**Bayside Council**

**Re: Bayside Council Response to Modification Eastlakes Shopping Centre (MP 09\_0146 MOD 2)**

Thank you for the provision of the applicant's response to Council's comments on 10 October 2017 on the "Modification to Condition B29(e) to allow larger construction vehicles up to 19 m in length to be used during construction".

DRAWING TITLE
**CONSTRUCTION PLATFORM
VEHICLE TURNING PATH**

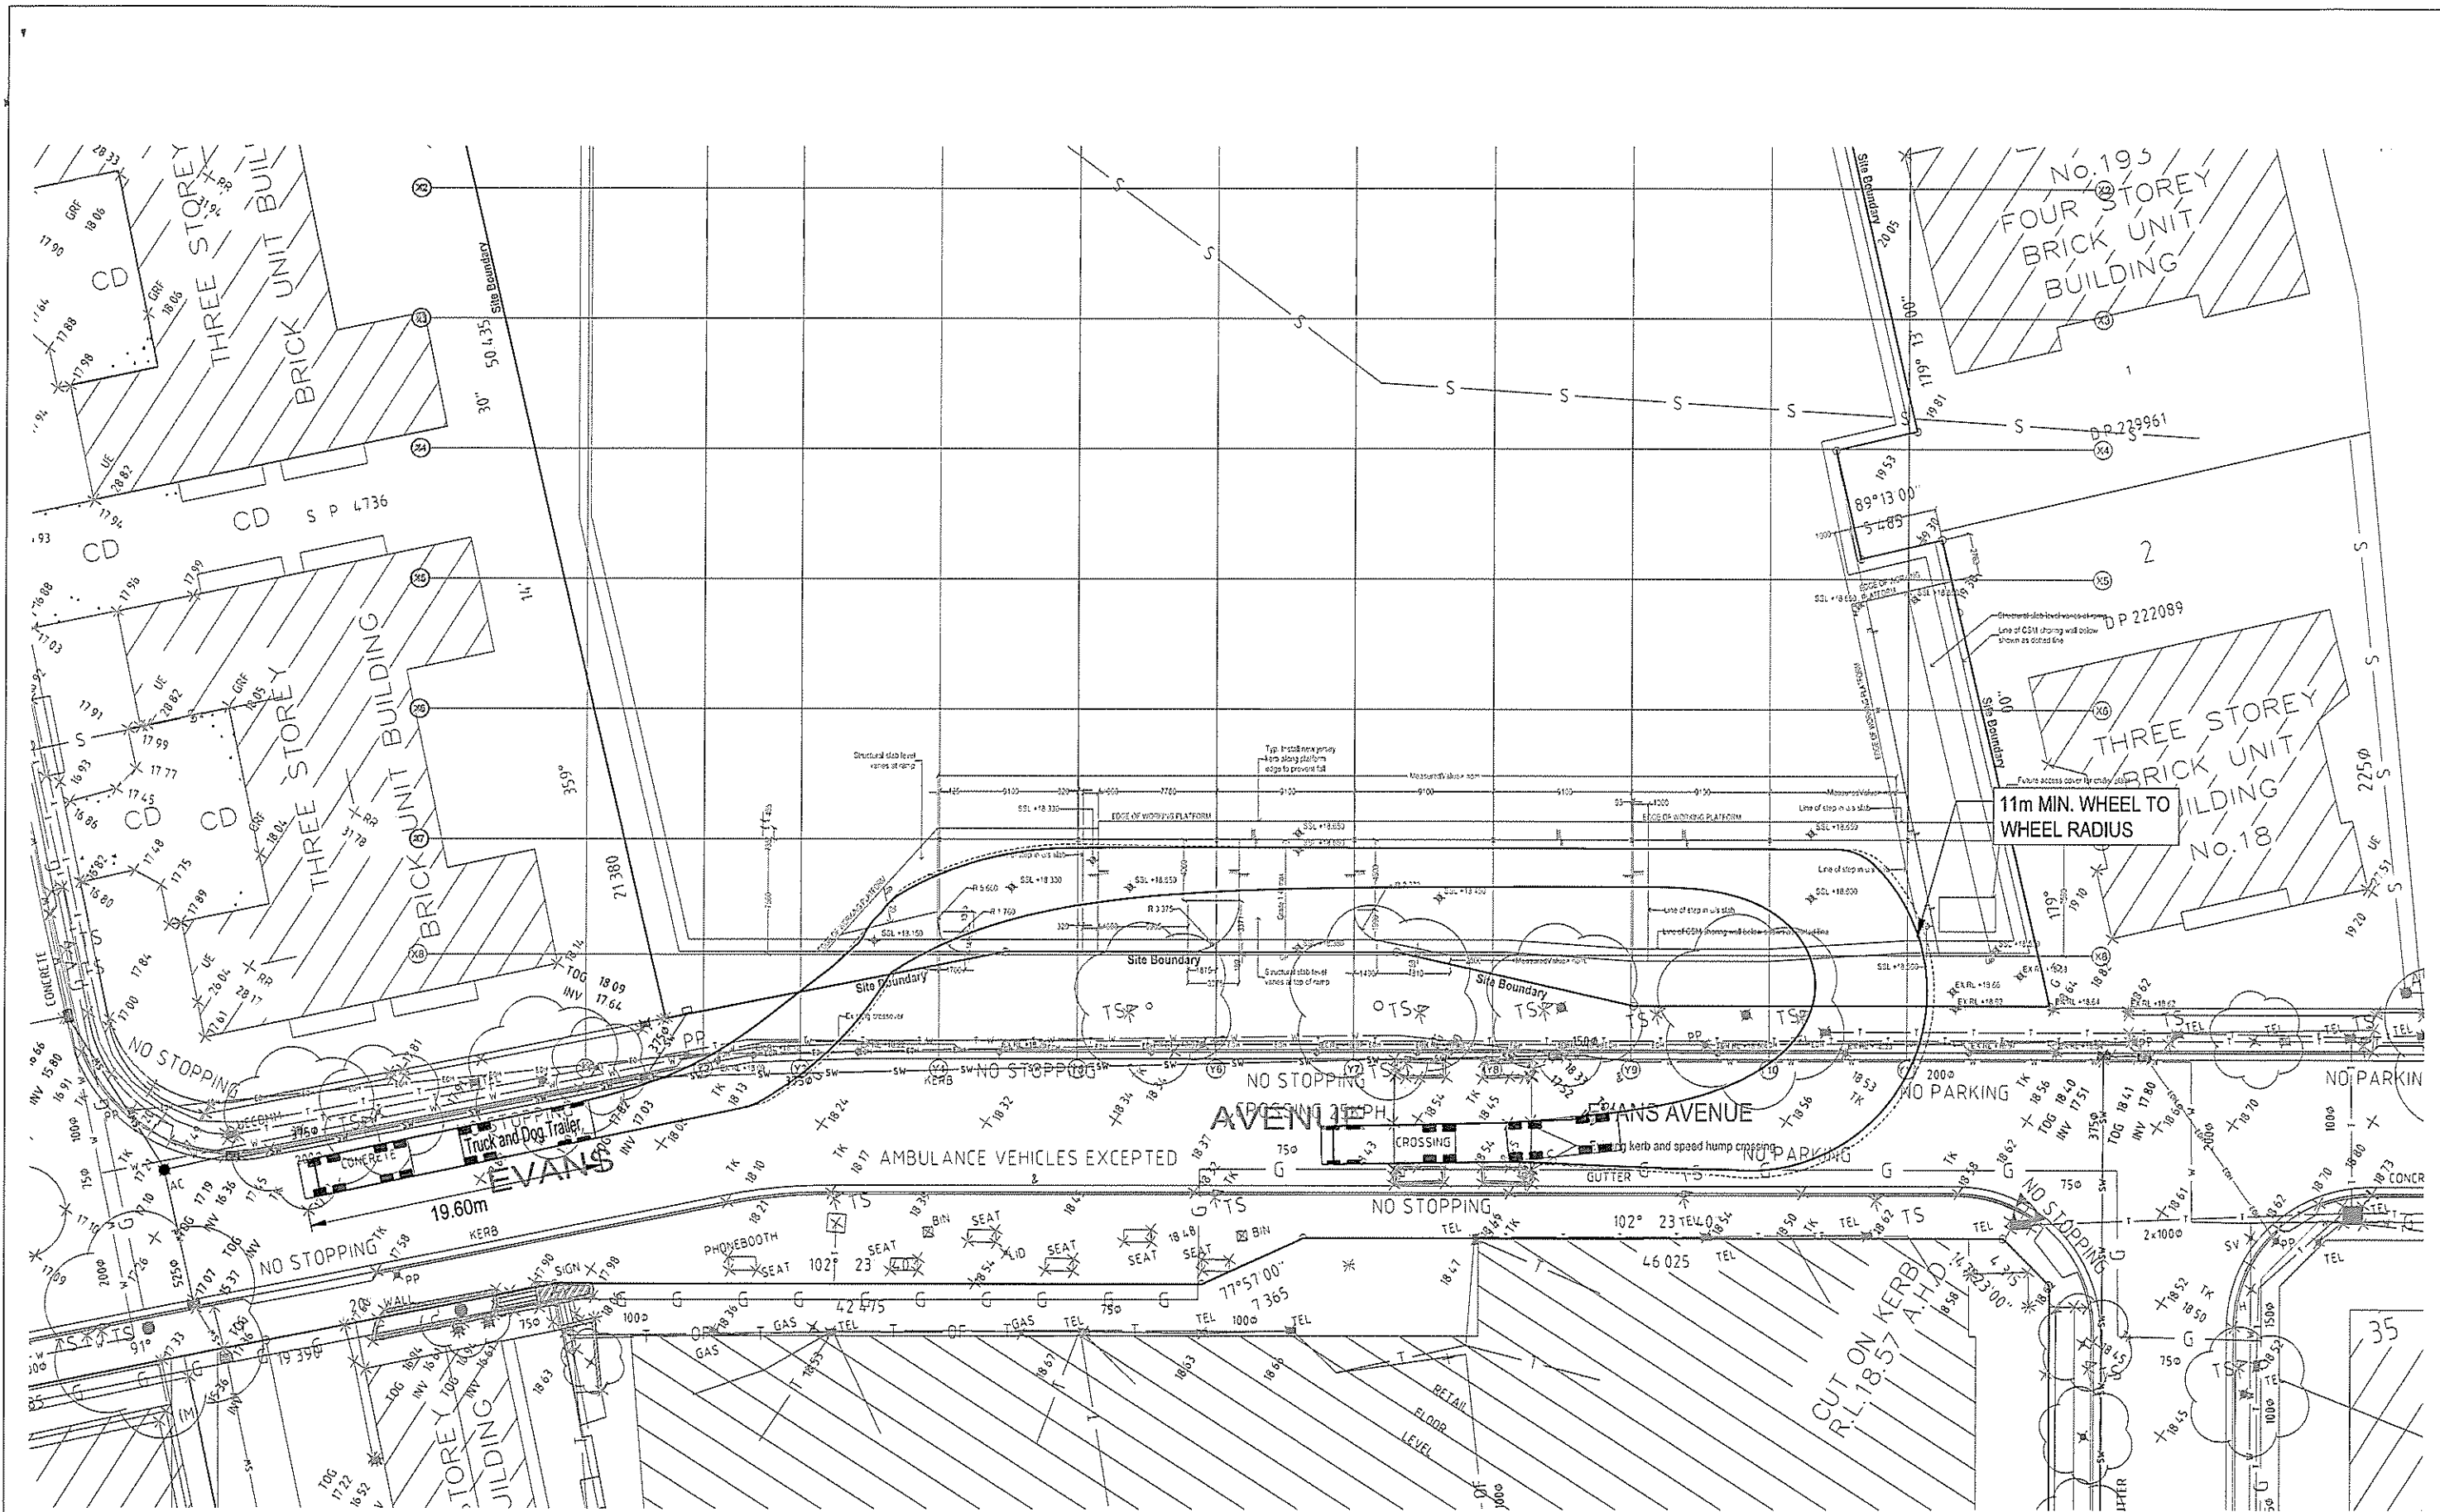
Council has reviewed the updated swept path analysis provided by the applicant and as long as these swept paths diagrams have been developed in accordance with the Australian Standards, Council has no further comments to make in this matter.
